MEMORANDUM

EPC Project No.: PPR2315

Re: Super Star Carwash – Claremont Business Park 2 – Drainage Compliance Letter

C5.2

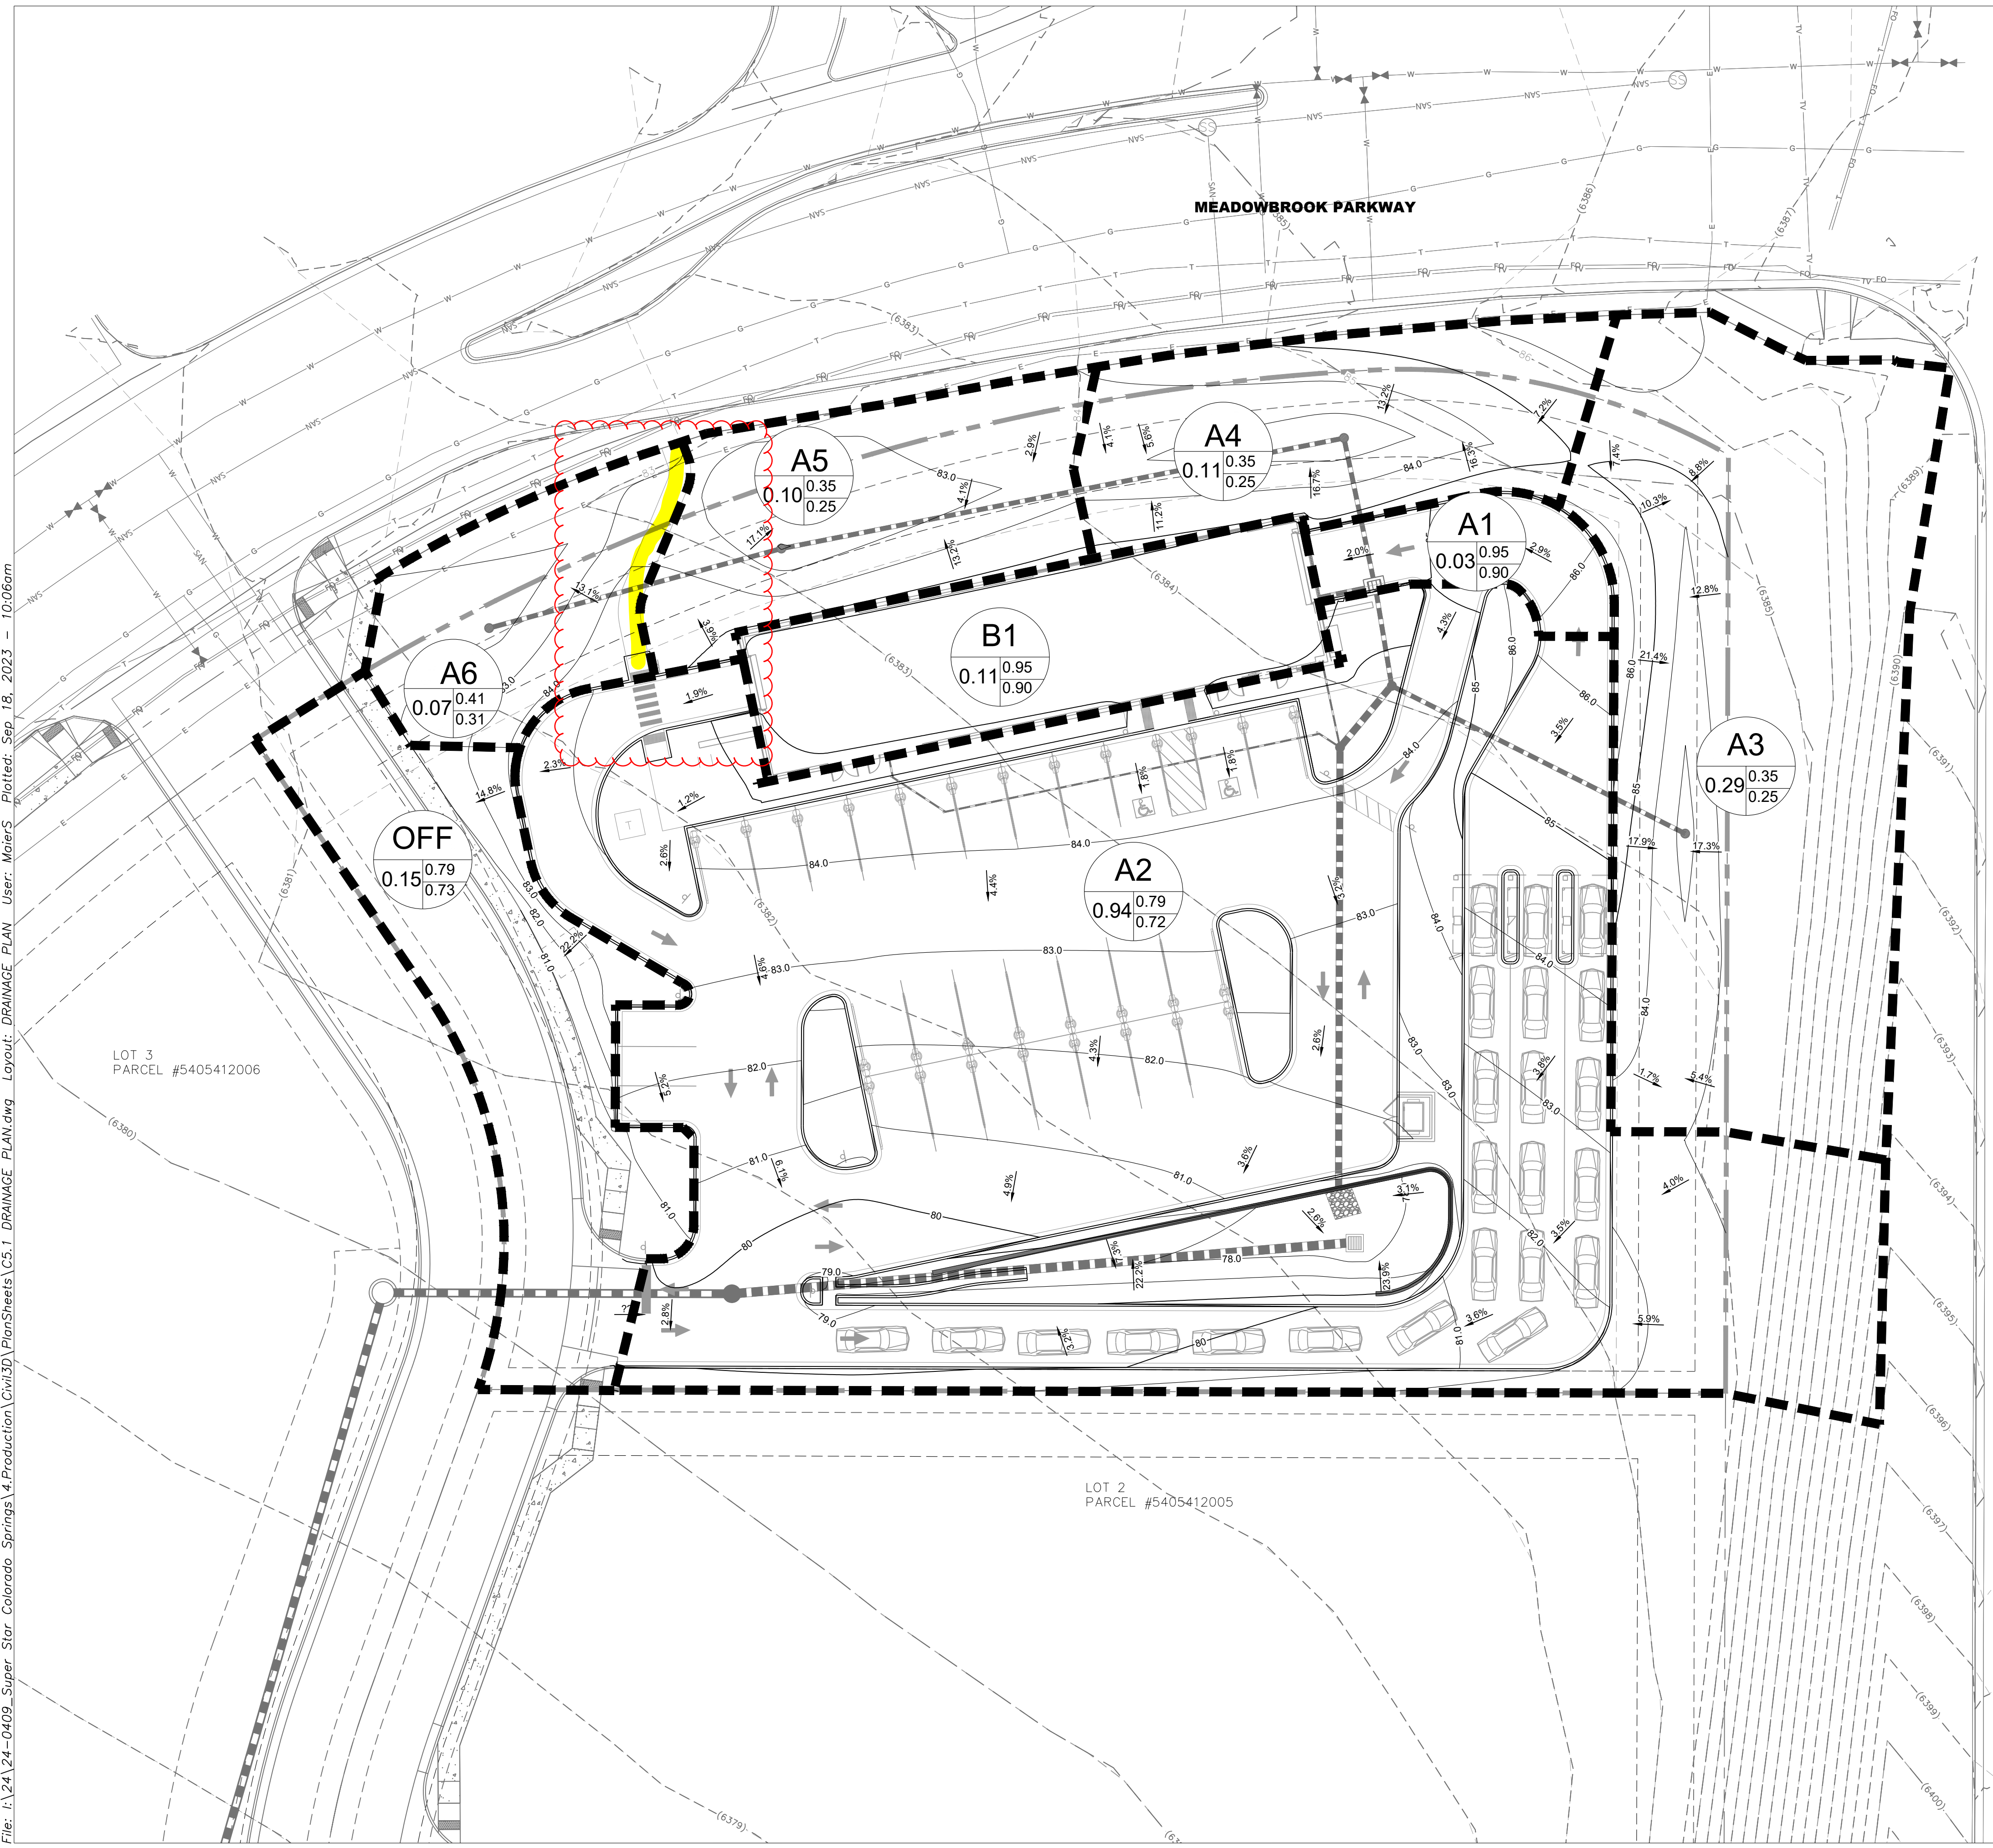
Please add Q Design Point to the drainage map and summary table
Label storm pipe and inlets sizes on the drainage map and the GEC Plan sheets
The drainage report and GEC plan set are approved by the County Engineer so must include those details. They seem to be reflect on the utility plan sheet within the SDP set.

Please label the runoff summary (cfs) and be consistent with the drainage legend as they show 10yr and the runoff summary as 5yr

Unresolved from Submittal 1, 2 - We need to know how much disturbed area is untreated and if there are any exclusions that apply to those areas. So please create a basic overview map (or modify an existing drainage map) with color shading/hatching that shows areas tributary to each PBMP (pond, runoff reduction, etc.) and those disturbed areas that are not treated by a PBMP, with the applicable exclusion labeled (ex: 20% up to 1ac of development can be excluded per ECM App 17.1.C.1 and exclusions listed in ECM App 17.1.B.#). An accompanying summary table on this map would also be very helpful (example provided):

This watershed has proposed landscaping/grading. 20% up to 1ac of development can be excluded per ECM App 17.1.C.1. State in the text and on this exhibit that this area is covered under that exclusion since it does not drain to the rain garden.

Correct flow arrow & grade
Arrow has been corrected.

Call out pad size and riprap type
Riprap size and type is now called out

The design points for each basin have been called out. Storm pipe and inlet sizes are labeled on the drainage plan.
The storm sewer pipe sizes and inlet sizes have been called out on the Erosion Control sheet. The drainage plan in Drainage Report has been updated to address these comments.

All drainage runoff values and coefficients have been updated to the 5-yr and 100-yr storm events.

The disturbed area that is untreated is called out and is now hatched. The table has been updated with more detail and shows which areas are being treated and which area is not.

This area is now shaded and is called out stating that it is not treated by the rain garden. The percentage of the site that is not treated has been added to the plans.
